Memorandum
Department of Planning and Development
Planning Division

To: Chair Delogu and Members of the Portland Planning Board
From: Rick Seeley, Senior Planner, GPCOG
Date: June 4, 2004
Re: June 8, 2004 Planning Board Meeting
Maine Medical Center Contract Zone
(Building Addition, Helipad, Parking Garage, and Central Utility Plant
Vicinity of Bramhall, Charles, Wescott, Ellsworth, Crescent, Gilman and
Congress Streets

EXHIBIT B, PAGE 14
PARKING GARAGE - EAST ELEVATION

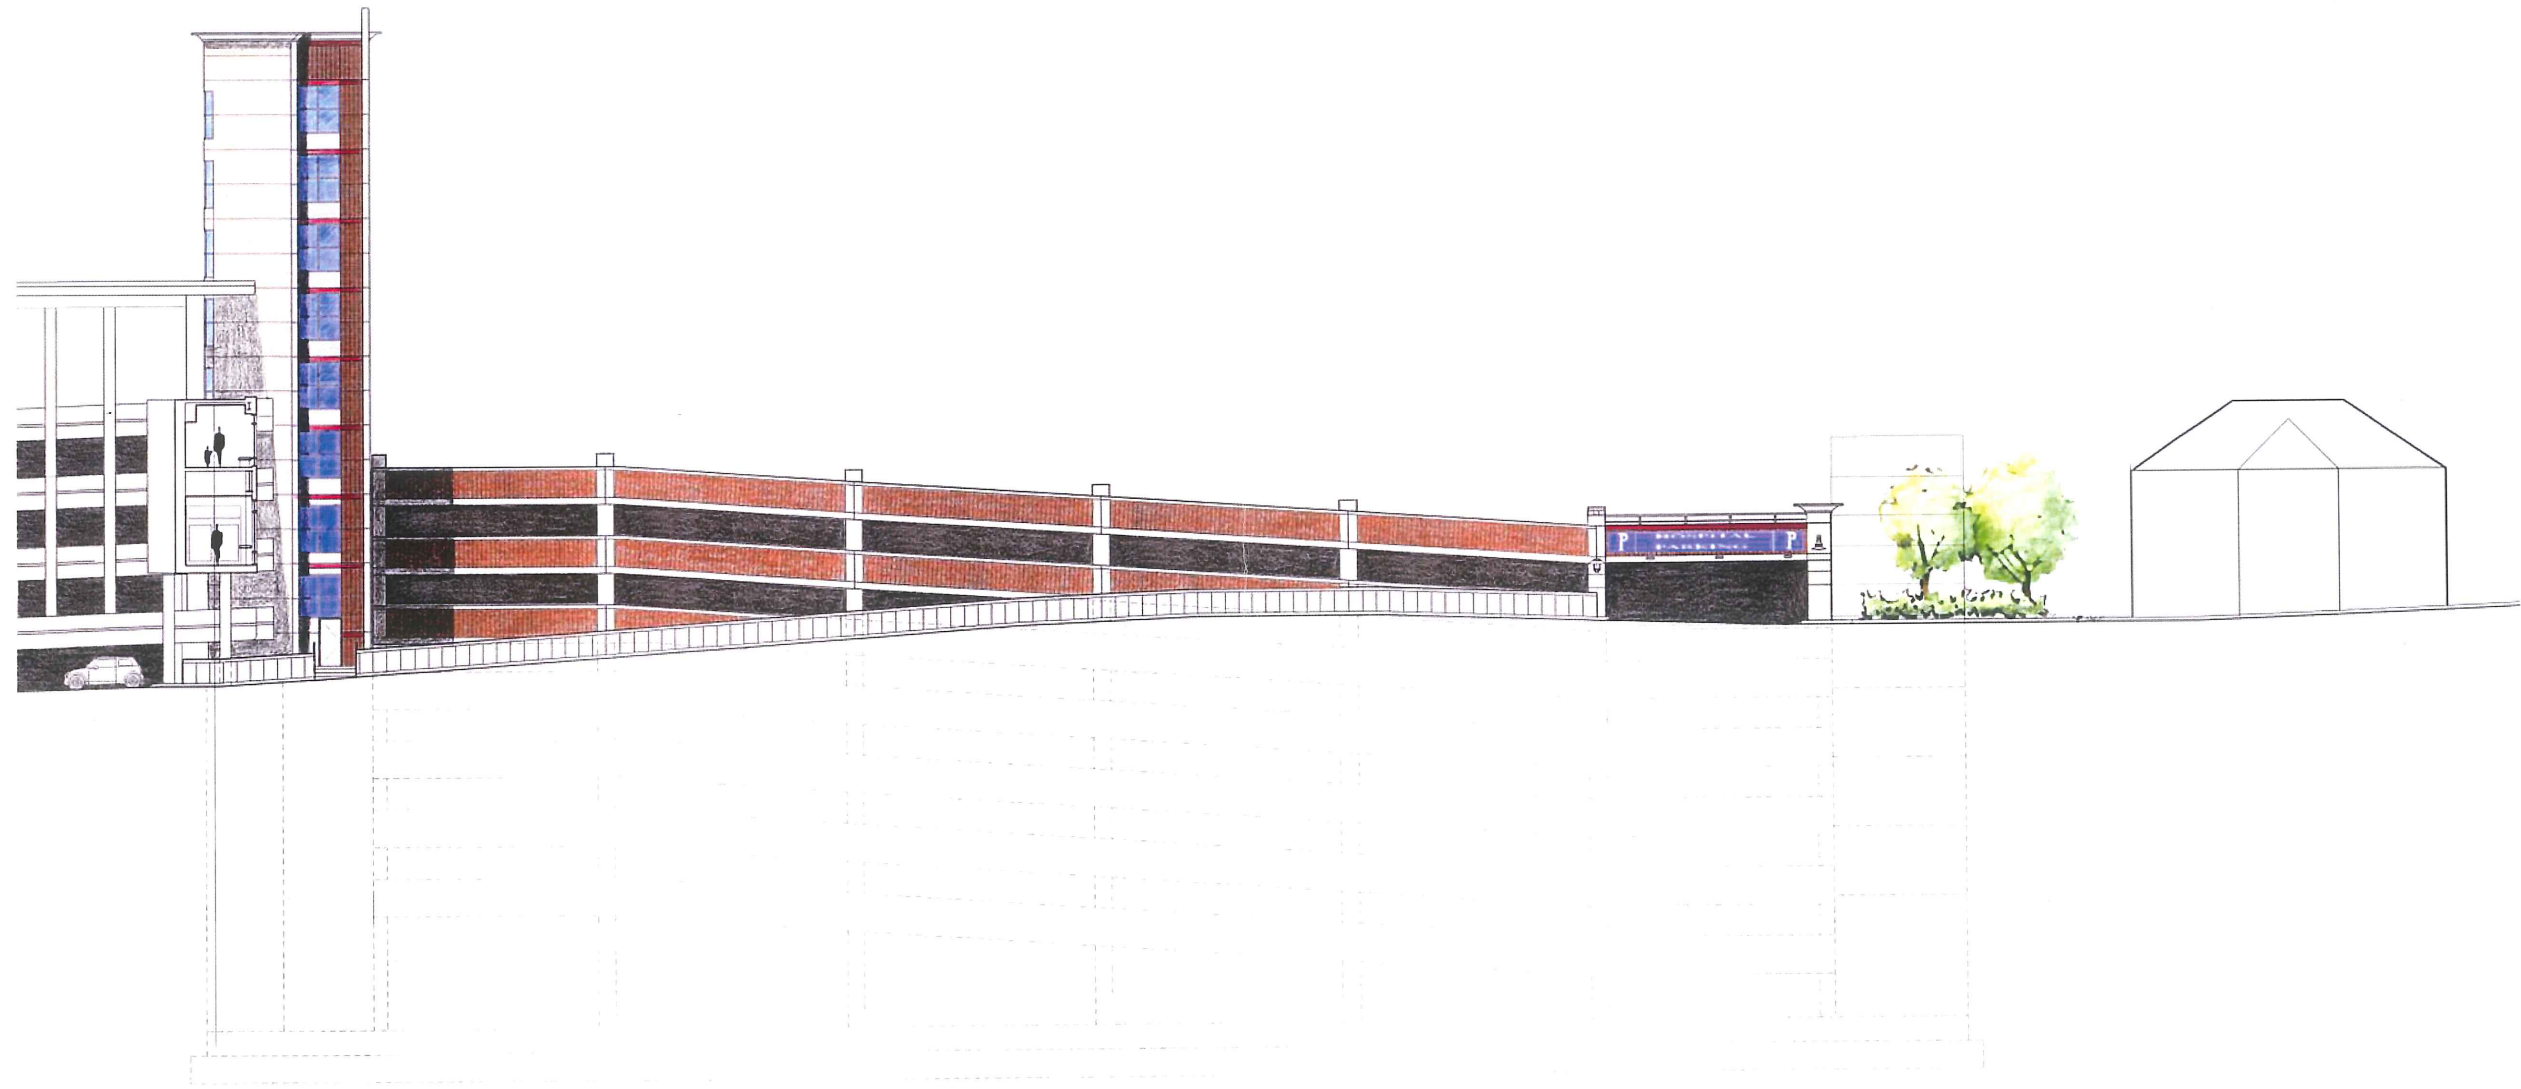
Parking Garage, Crescent Street Entrance. There is also a Crescent Street, upper level entrance to the proposed new parking garage, as noted in previous submissions. However, an elevation drawing is required showing how this entrance and the related façade, on either the east side facing the neighborhood or the south side, facing the emergency department entrance, the Richards Wing, the Bean Building and the new Charles Street addition will appear. Accordingly, staff is requesting, but has not yet received, elevation drawings showing an elevation view of the Crescent Street entrance and the southeastern corner of the new parking garage. What specific design elements such an elevation view will show, will depend at least in part on the Planning Board's guidance at the June 8th workshop.

Extend the brick and cleaved stone block theme of the Charles Street addition to the façade of the new parking garage. Do not limit brick to just the first story, there should be brick elements throughout the multiple levels facing Crescent Street and the residences to the east of the garage.

Ribbons should be brick.

The application describes but does not show shielding on the upper stories to limit headlight glare onto neighboring residential uses. This should be shown in the elevation view requested.
